From: Amanda Scholes on behalf of Planning.Responses
Sent: 22 December 2017 09:55
To: Planning Scanning
Subject: FW: Planning Application AW/328/17/OUT - 14 Princess Avenue - Aldwick
Attachments: 14 Princess Avenue - Lettter to Arun District Council 1a - 21 12 2017.doc; Image 1 - Arcs of Overlooking from proposed development 14 Princess Avenue.jpg; Image 2 - Massing and overlooking of La Casita & Seagull.jpg; Image 3- Massing and Overlooking of Seagull.jpg; Image 4 - Overlooking at Seagull showing new high level windows.jpg

RE: Planning Application - AW/328/17/OUT – 14 Princess Avenue – Aldwick

Would you please take this letter as formal notice of a number of strong objections we have to the above planning application which seeks to convert the existing single dwelling at 14 Princess Avenue, Aldwick into five flats.

Proposed First Floor Plan

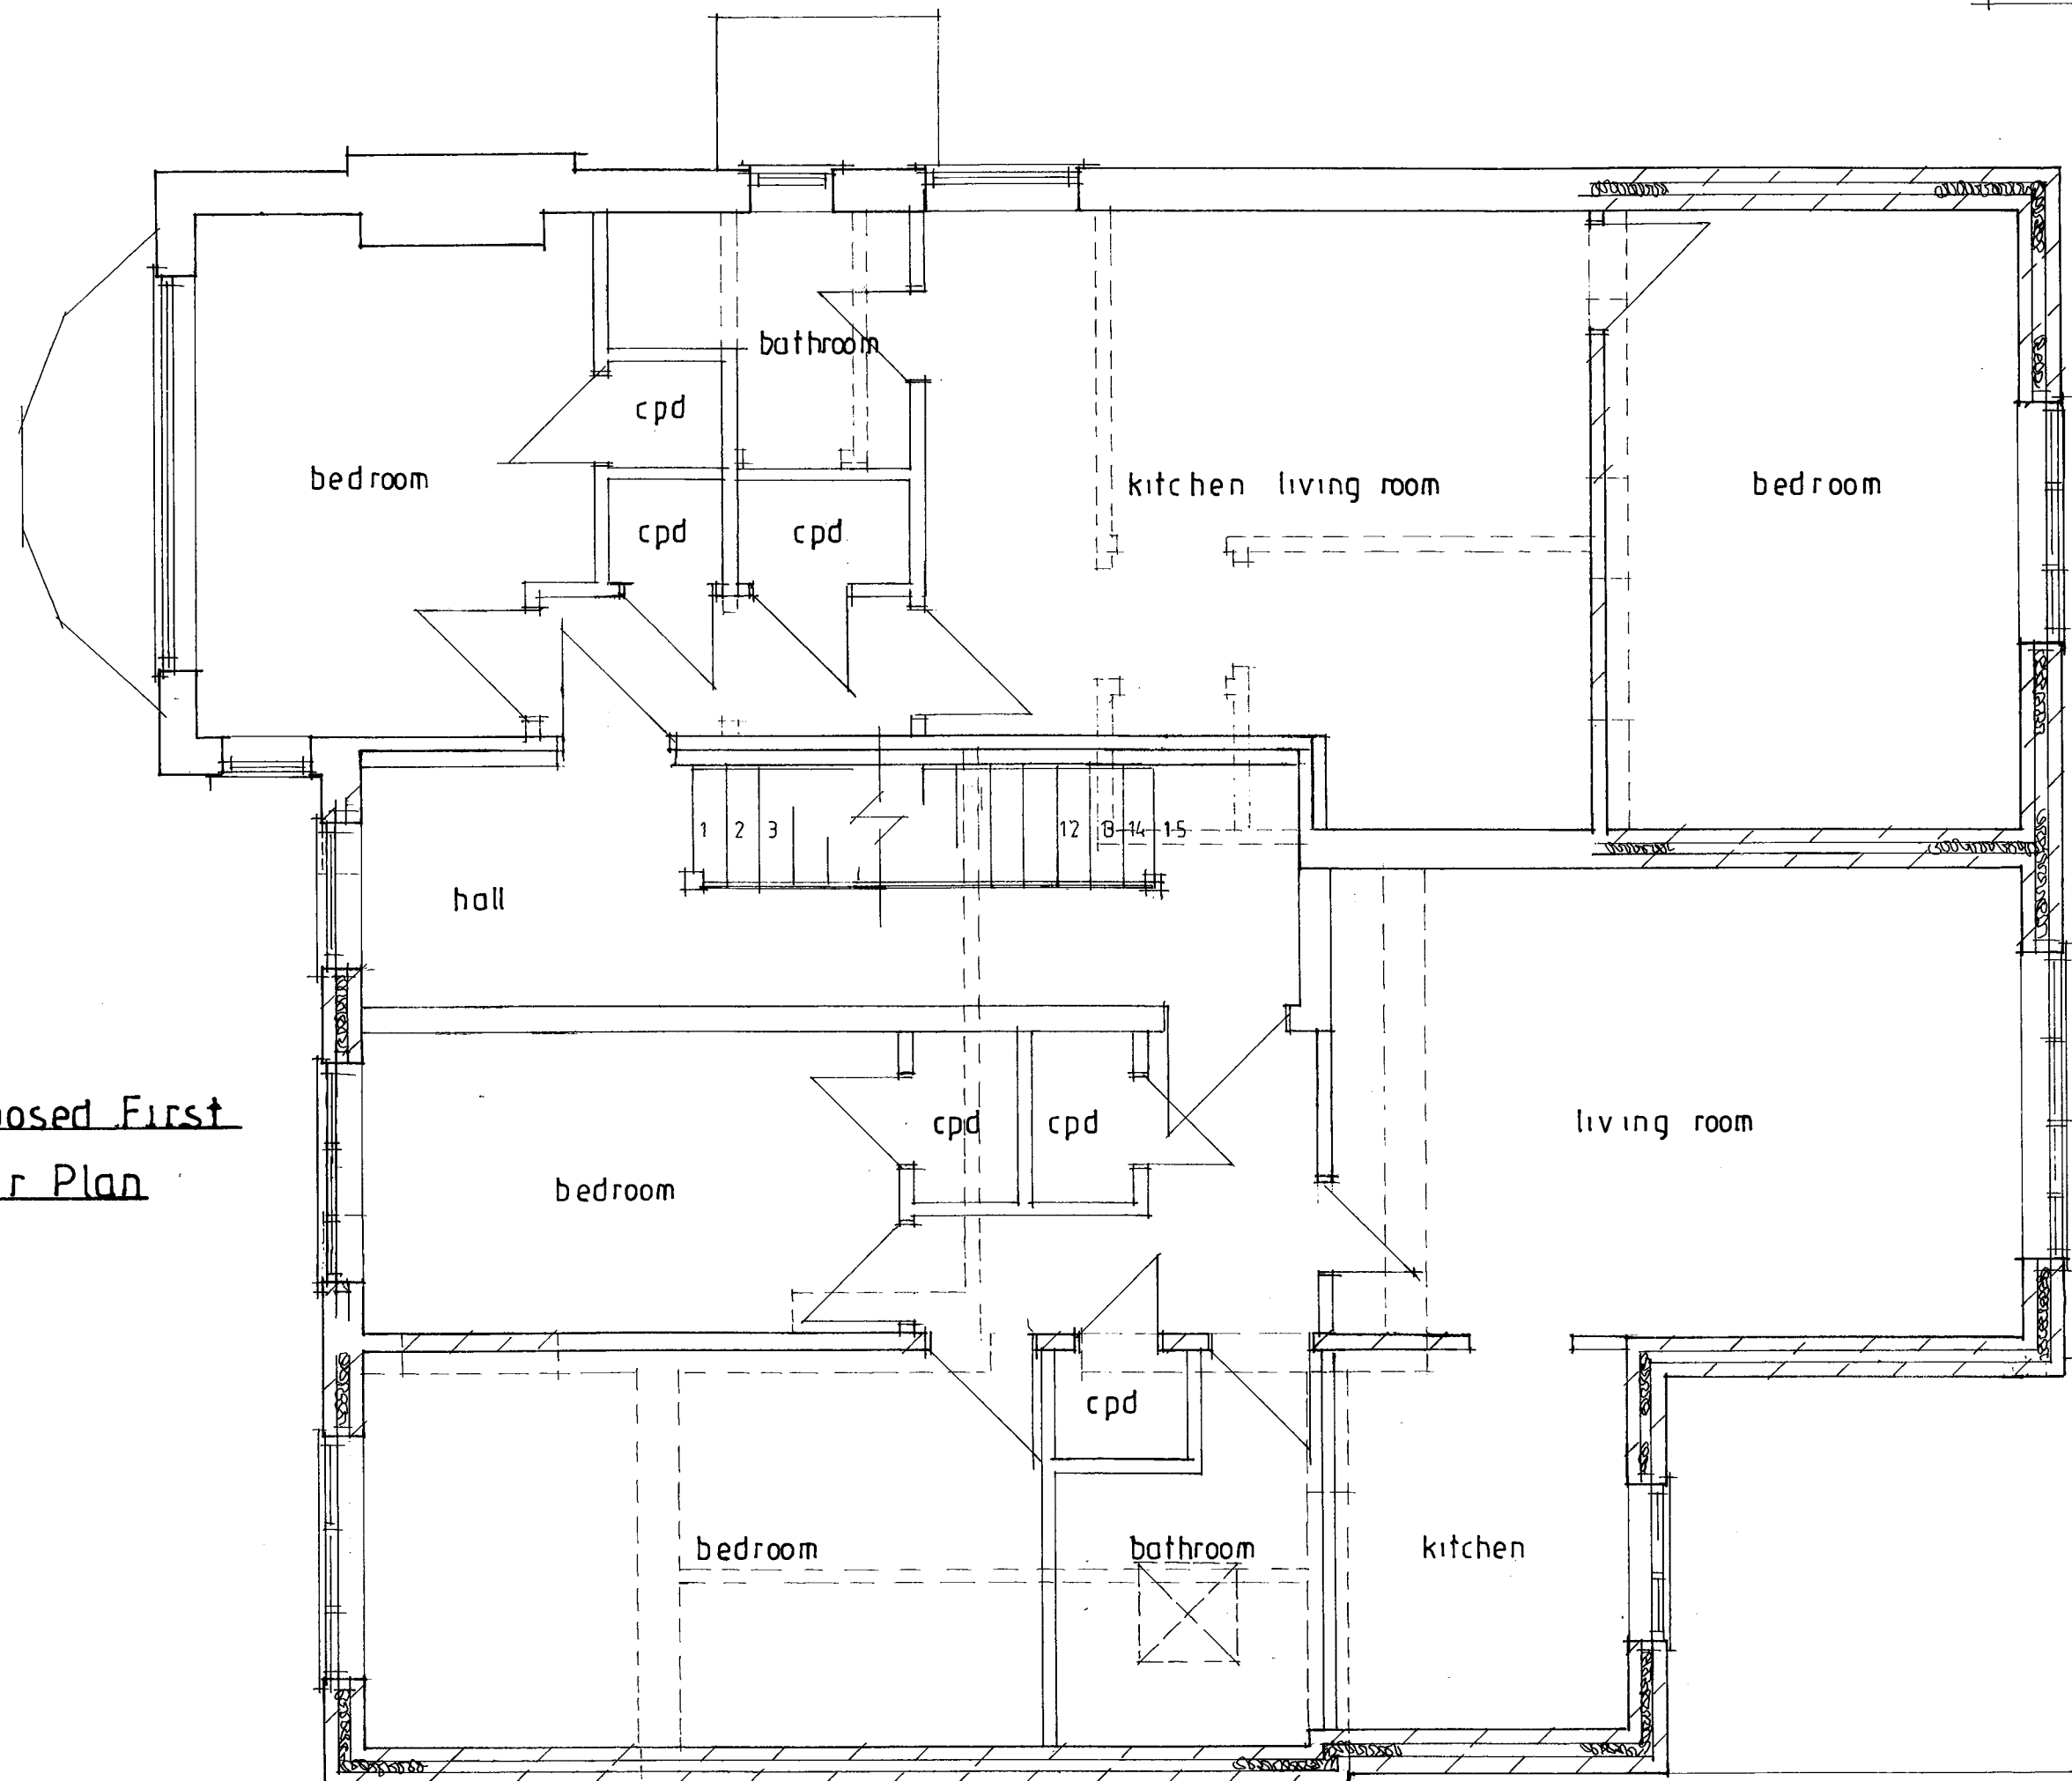
The windows of the first and second floor flats at the rear of the new building give the occupiers of those flats a permanent and penetrating view into the private rooms and gardens of family homes; La Casita and Seagull.

Image 1 – 'Arcs of Overlooking from proposed development at 14 Princess Avenue,' shows just how great the loss of privacy will be for the residents of neighbouring private family houses La Casita and Seagull. The 'red and blue arcs of view' from the rear facing windows of Second Floor Flat 5 show that there will be no privacy

Similarly Image 1 again shows that occupants of rear facing First Floor Flats 3 and 4, will from their windows, be able to view anything and everything in the purple and orange arcs of view into the private gardens and rear facing private rooms of La Casita and Seagull.

Drg No.: SBS/221/06C

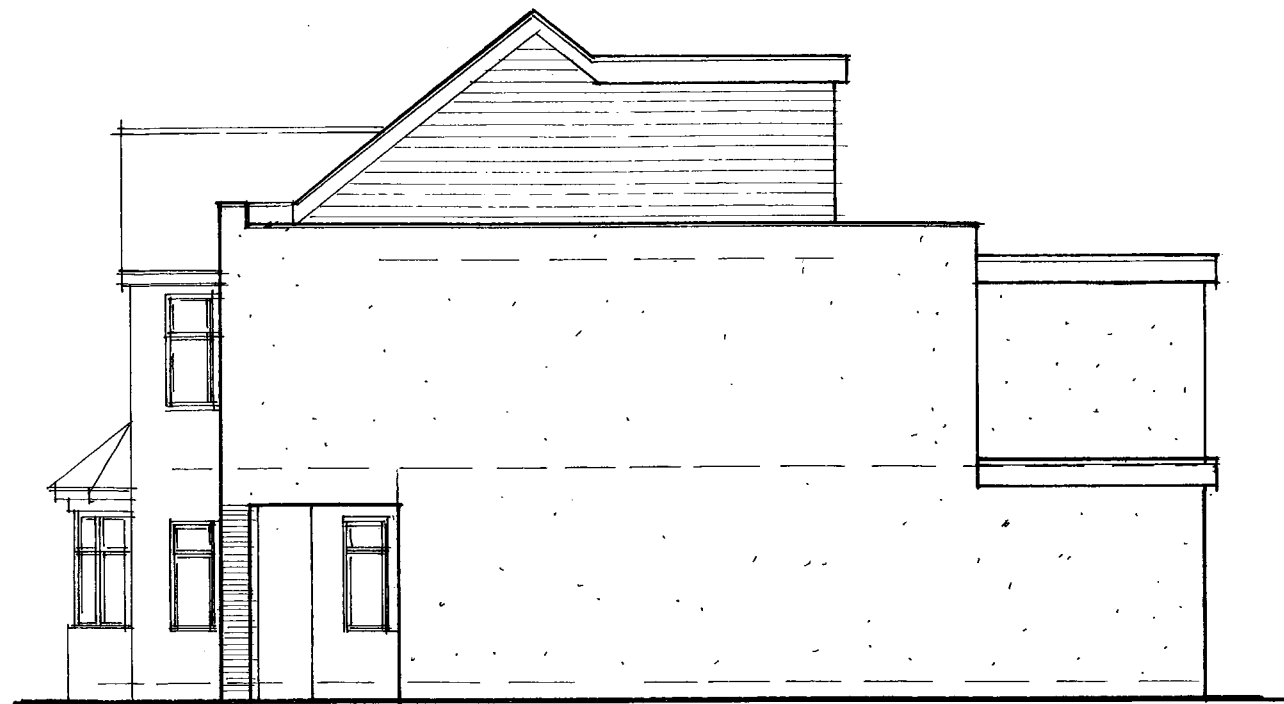
The planning application proposes significant structural changes to the rear of the existing house at 14 Princess Avenue. The extent to which these, in height, in width and in substantially increased volume, (massing), constitute an overbearing structure, can be seen in the illustrations accompanying this letter. The greatest changes come at the rear of the proposed design. This is where the sheer volume of the increase in accommodation becomes immediately apparent. The proposed building dominates and greatly overlooks the private rooms and gardens of our home and of neighbouring properties. This conversion is by no means 'visually subservient' to the remainder of the existing building - but utterly dominates it. This is in conflict with the Arun District Local Plan 2003 – Policy Dev 19 (ii).

Image 2, Image 3 and Image 4, show how the height and sheer volume of the proposed development will dominate and have an overwhelming and overbearing effect on neighbouring properties. In each case an un-modified photograph of the existing building is shown for comparison.

Proposed Second
Floor Plan

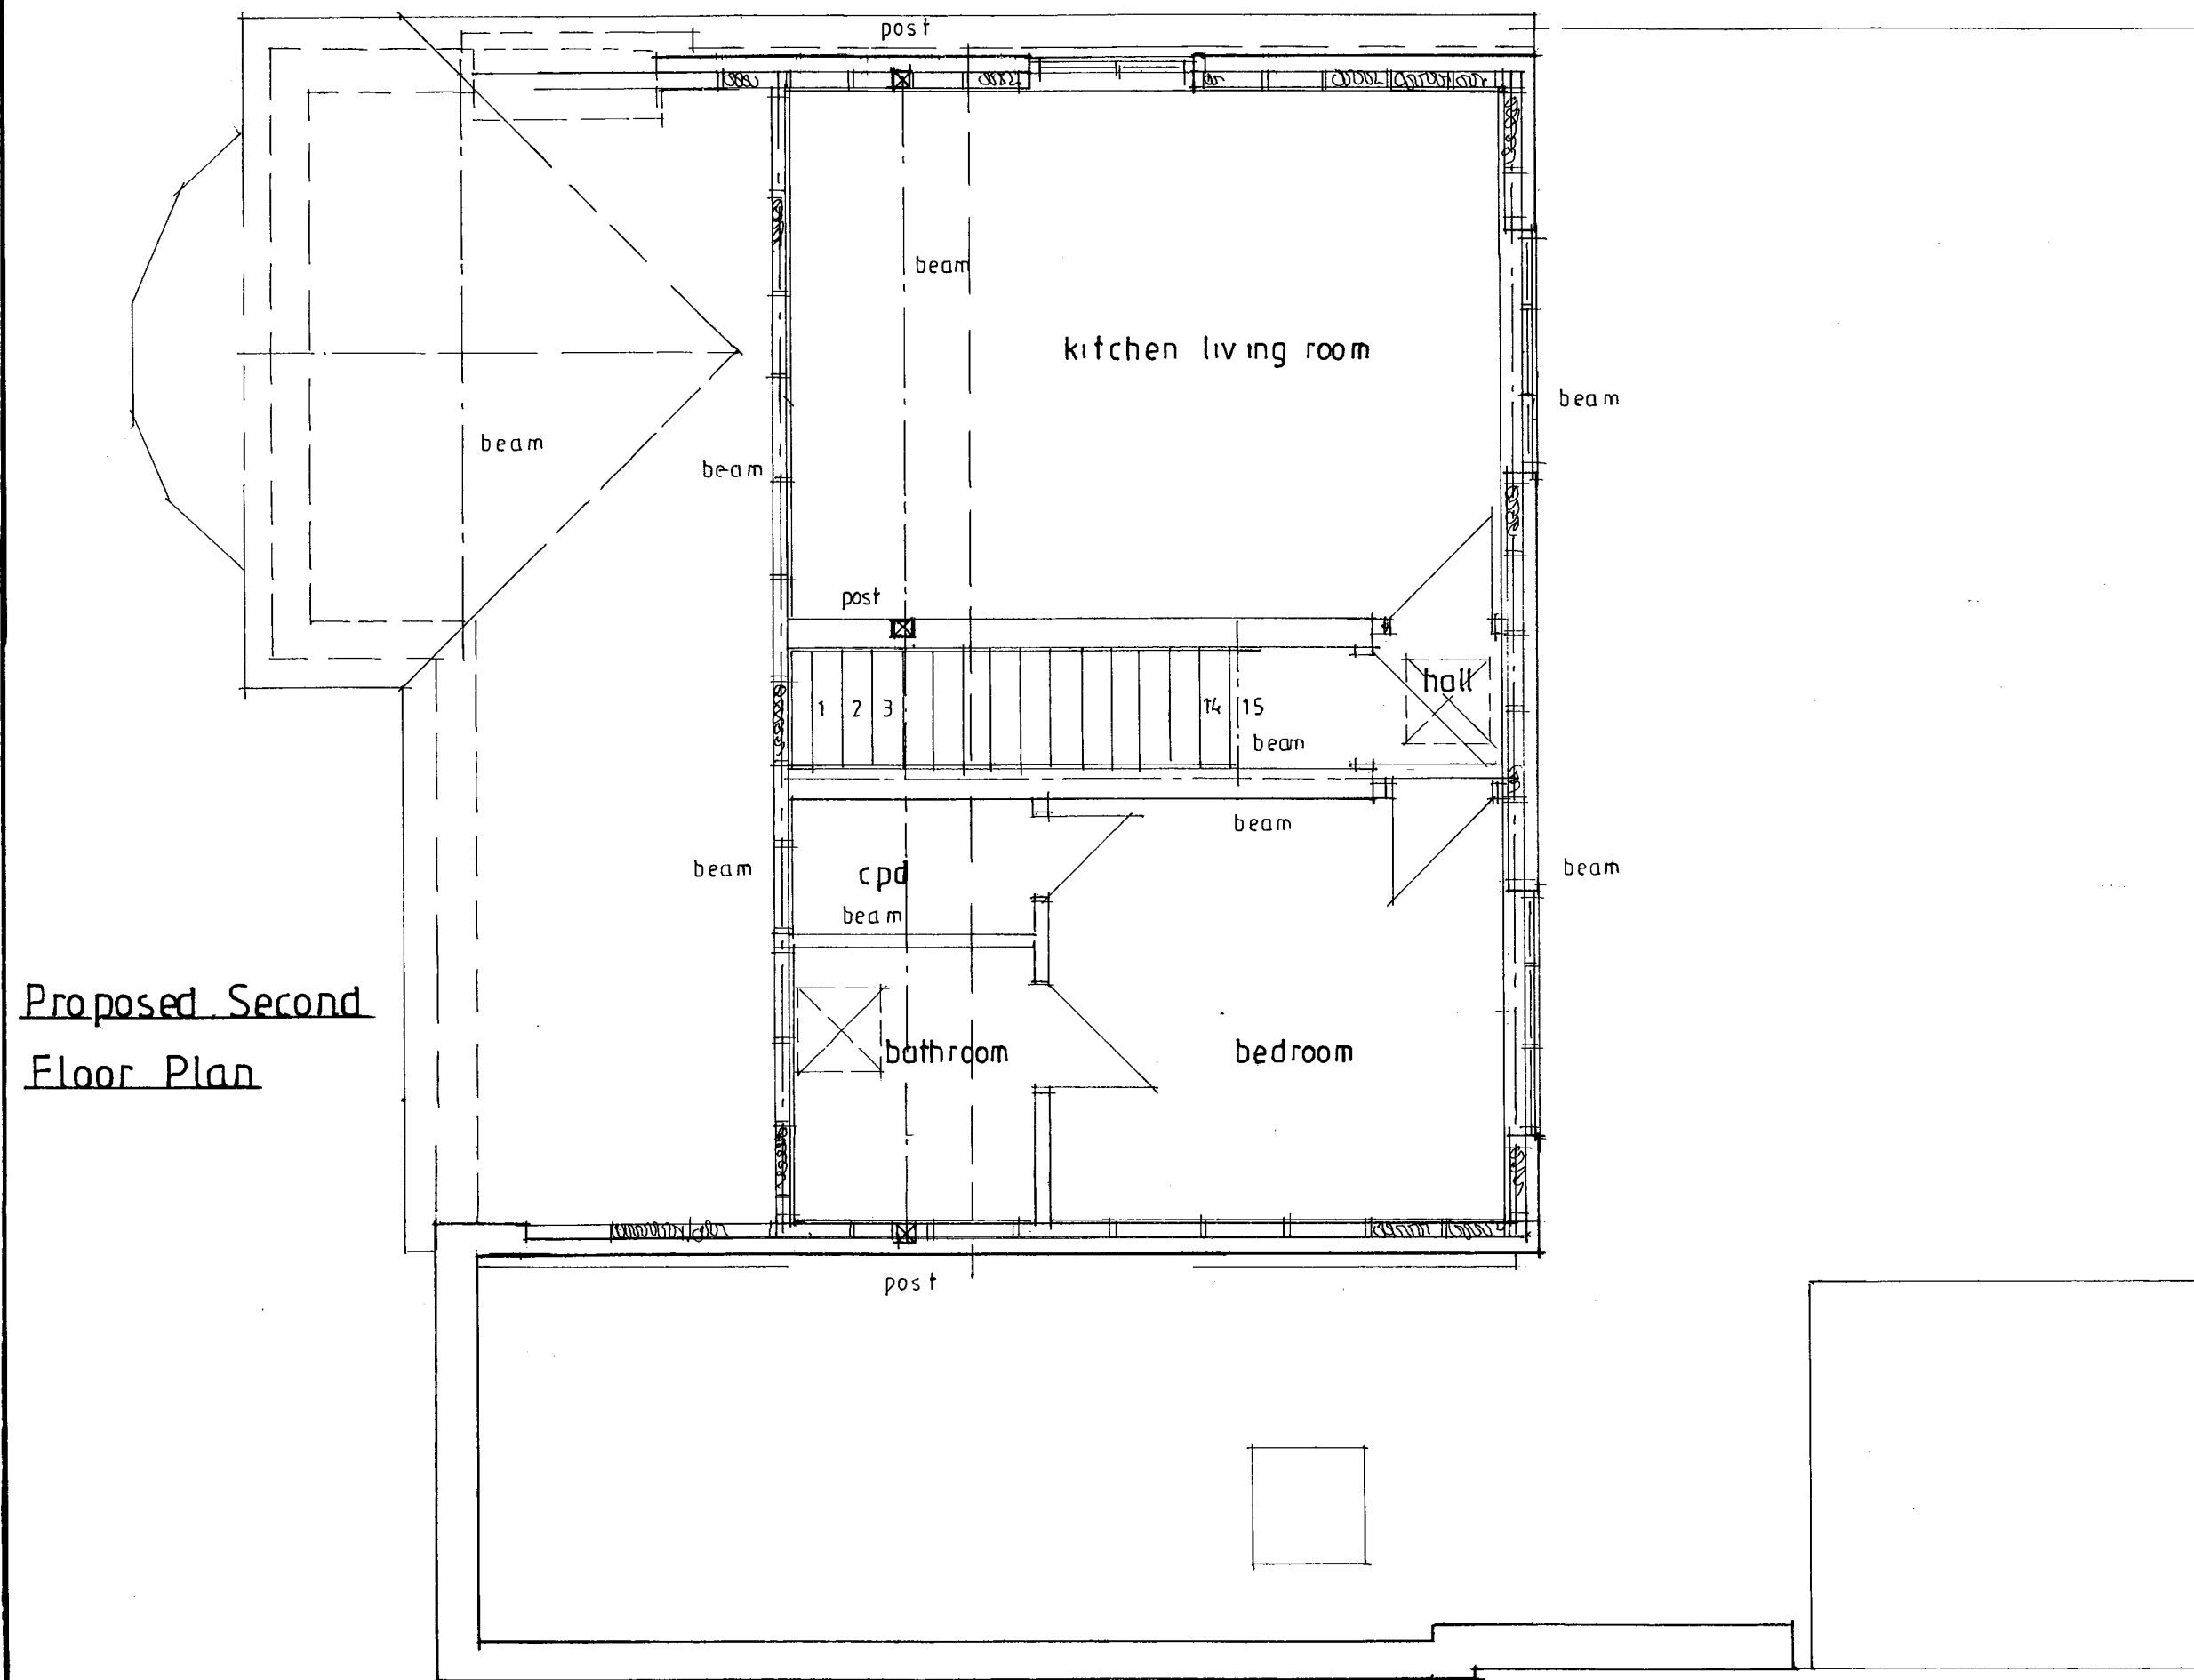
whatsoever to be had in the gardens or rear private rooms of La Casita and Seagull if this Planning Application is approved.

Drg No.: SBS/221/11

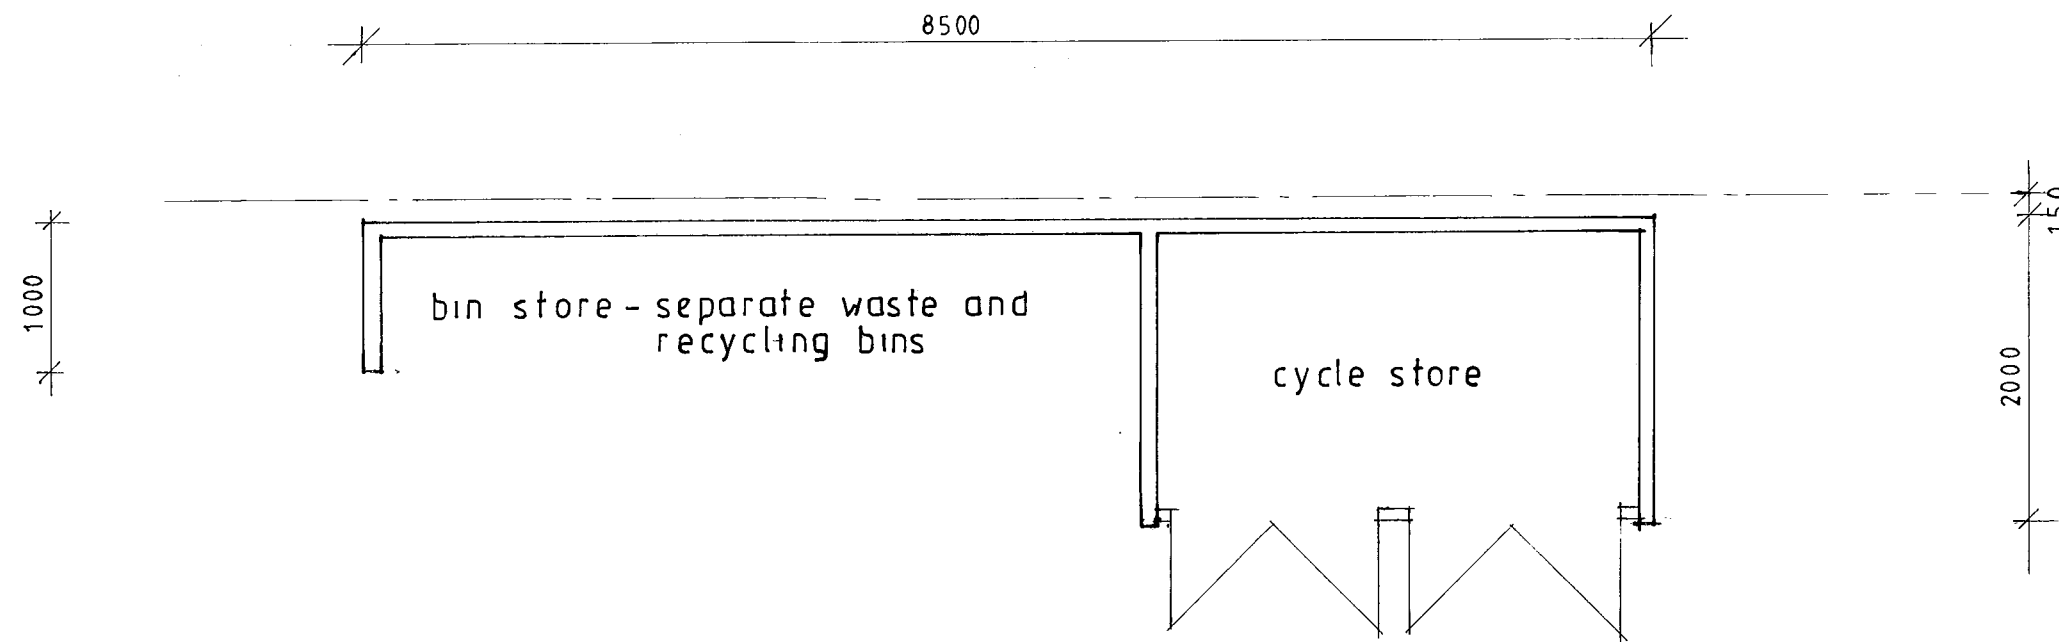
In support of their application the Applicant has submitted a Drawing No. SBS/221/10A entitled Proposed Flat Conversion – Site Plan. The drawing shows at the northern side of the 'Communal Gardens' a Bin Store and a Cycle Store. These structures are further shown in Drawing No. SBS/221/11 Proposed Flat Conversion – Cycle & Bin Store.

In the rear garden the sizable trees next to the north wall of the garden will need to be completely removed in order to build the Waste Bin Store and the Cycle Store as shown in Drawing SBS/221/10A – Site Plan.
